Re: Application ref 2026-91228 – East Bierley Memorial Garden, South View Road, Bradford BD4 6PH

Proposal: Works to trees at East Bierley Memorial Garden (conservation area / TPO)

PHOTO 5

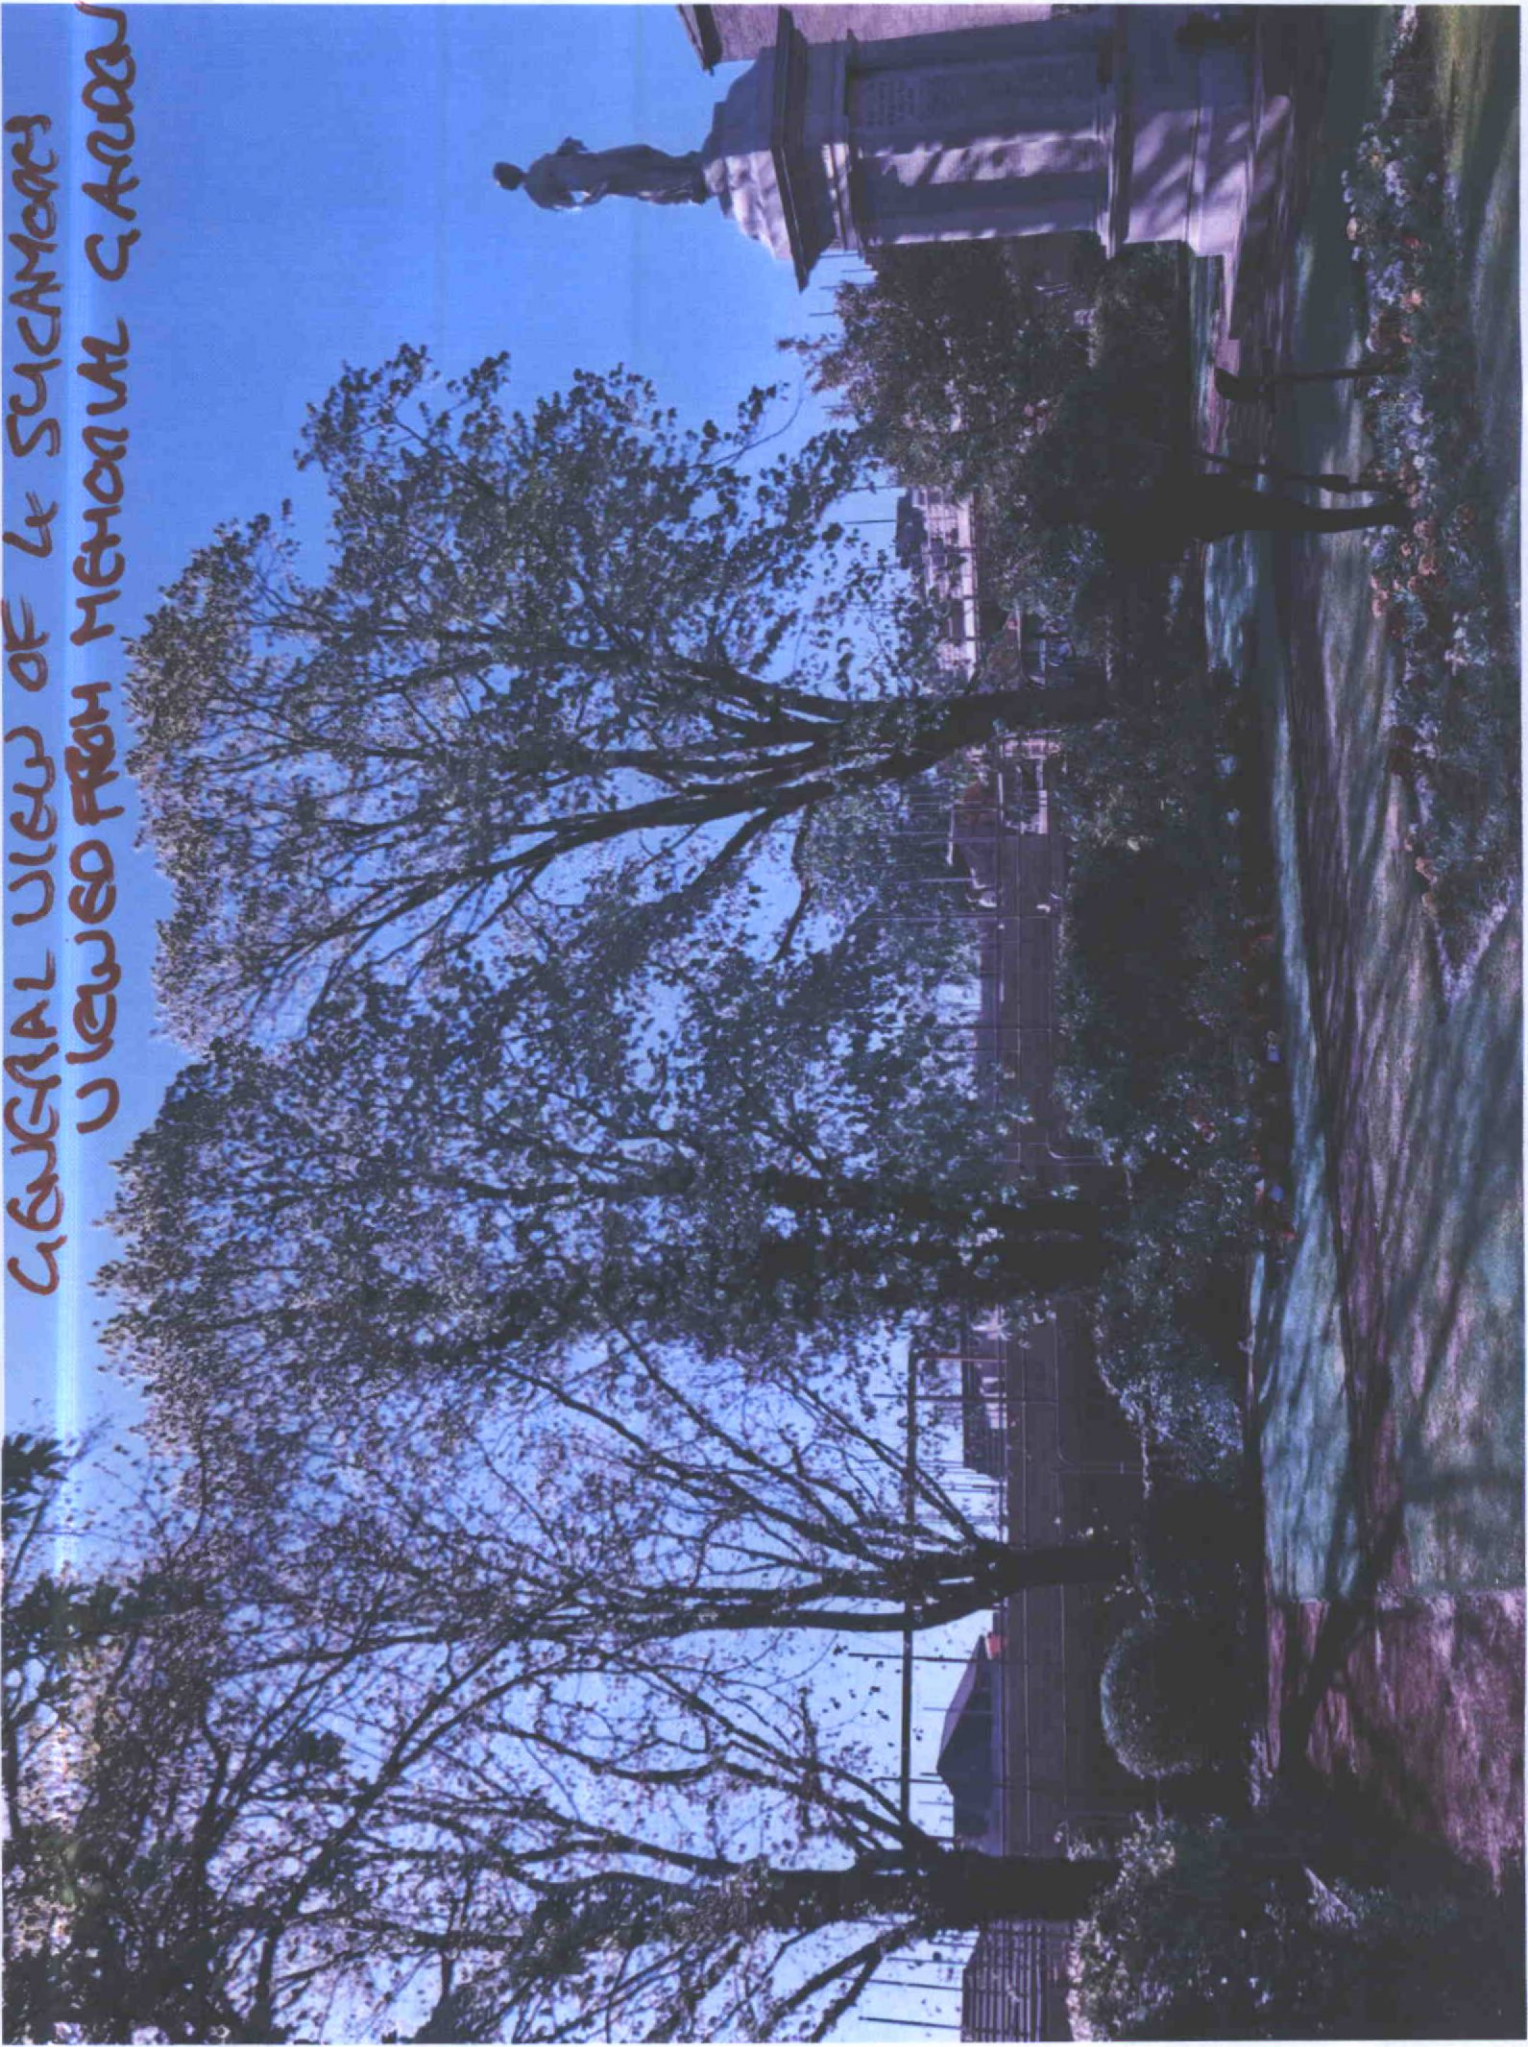
The application, submitted by David Hirst on behalf of the East Bierley Village Preservation Society, (EBVPS) requests branch reductions on "**4 sycamore trees**" along the boundary wall. **This is factually incorrect. The trees in question are the memorial lime trees (*Tilia* sp.), which are botanically distinct from sycamores in every season.**

- It identifies only four sycamores on the rear boundary, not the memorial lime trees.
- The submitted plan and photographs support only branch reduction works to those sycamores.
